Your ref
BR/178/19/PL

Our ref
PLAN-028853

Proposal: Existing ground floor flat converted into 2 No. one bedroom apartments with single storey side extension & rear orangery.

Site: BR/178/19/PL: - Delawarr House, Flat 1 144 Aldwick Road, Bognor Regis, PO21 2PA.

PROPOSED GROUND FLOOR PLAN
Scale 1:50

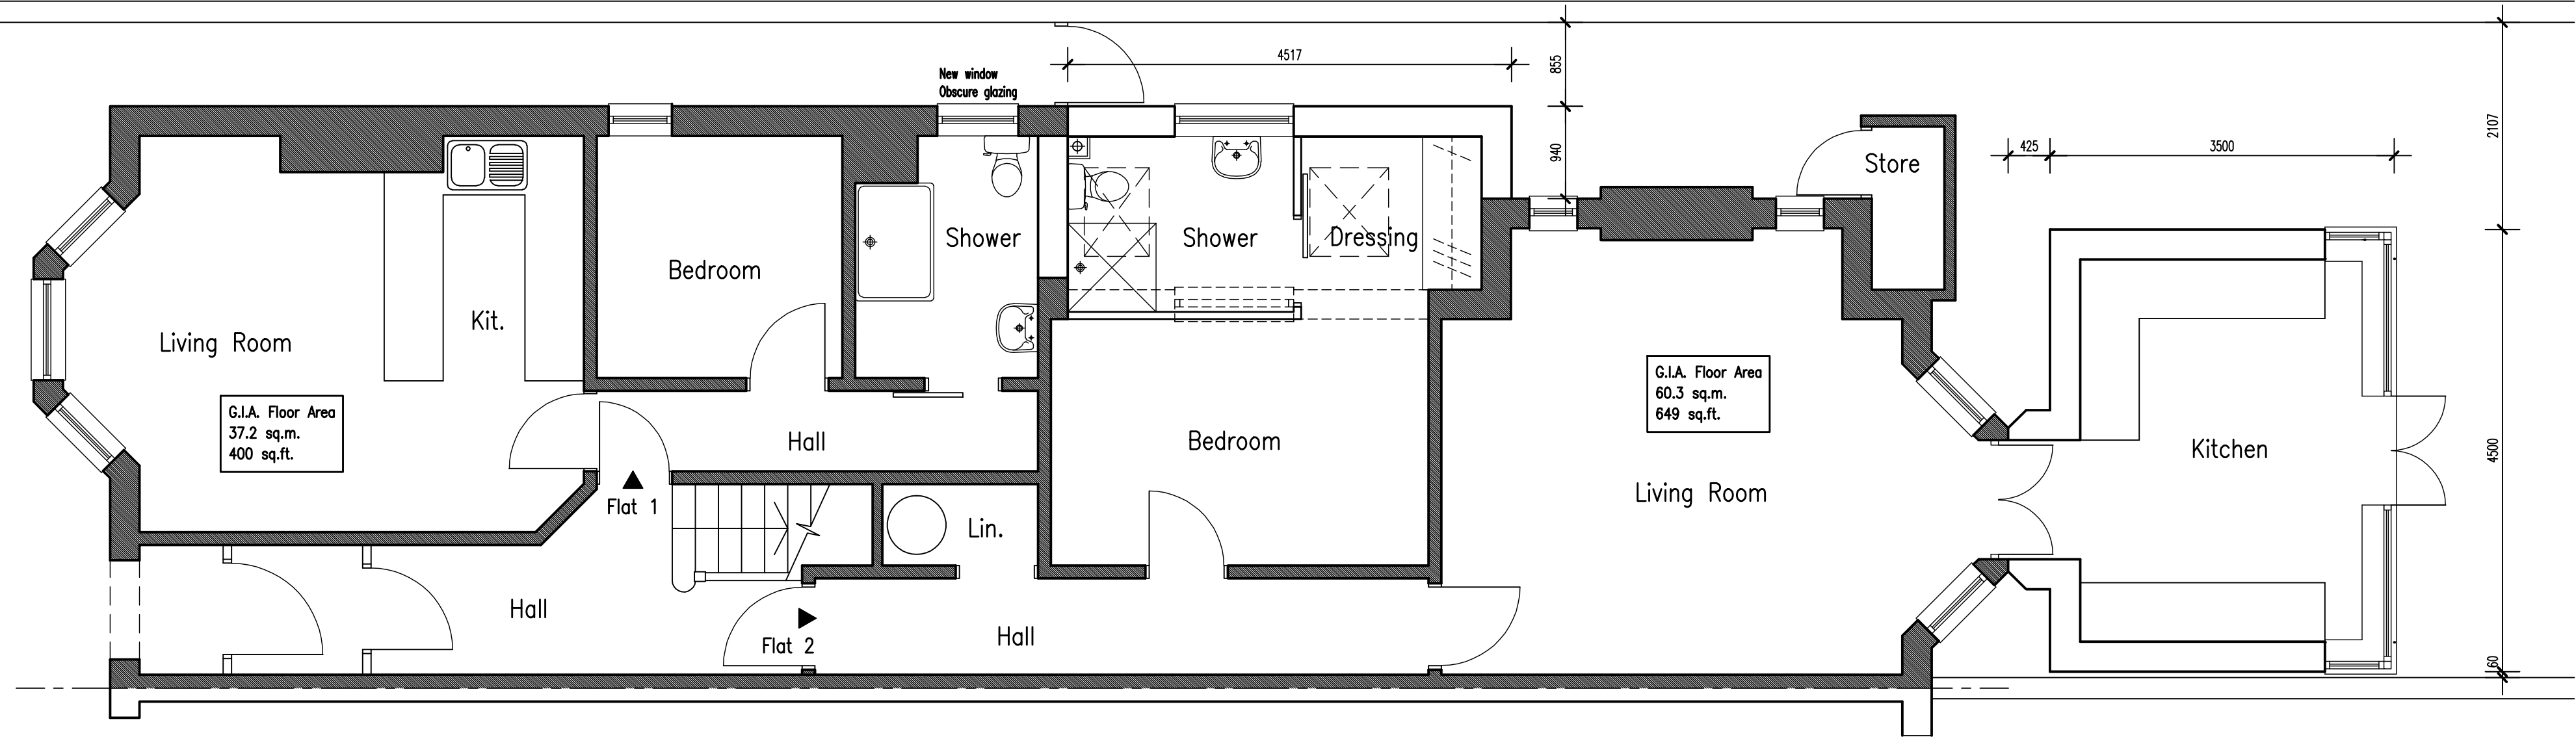
The attached plan shows that the proposed development will lie over a public foul sewer. An investigation of the sewer is required to confirm its size and depth, to ascertain its condition, the number of properties served, and potential means of access, before any decision can be made as to whether it would be acceptable for Southern Water to allow building over the sewer. The length of sewer to be built over, under the terms of Part H of the Building Regulations dictates that the matter is determined by the sewerage undertaker – in this case Southern Water. The applicant is advised to apply for approval of works through Build Over Public Sewer application process.

In order to protect drainage apparatus, Southern Water requests that if consent is granted, a condition is attached to the planning permission. For example, "The developer must advise the local authority (in consultation with Southern Water) of the measures which will be undertaken to protect the public sewers, prior to the commencement of the development."
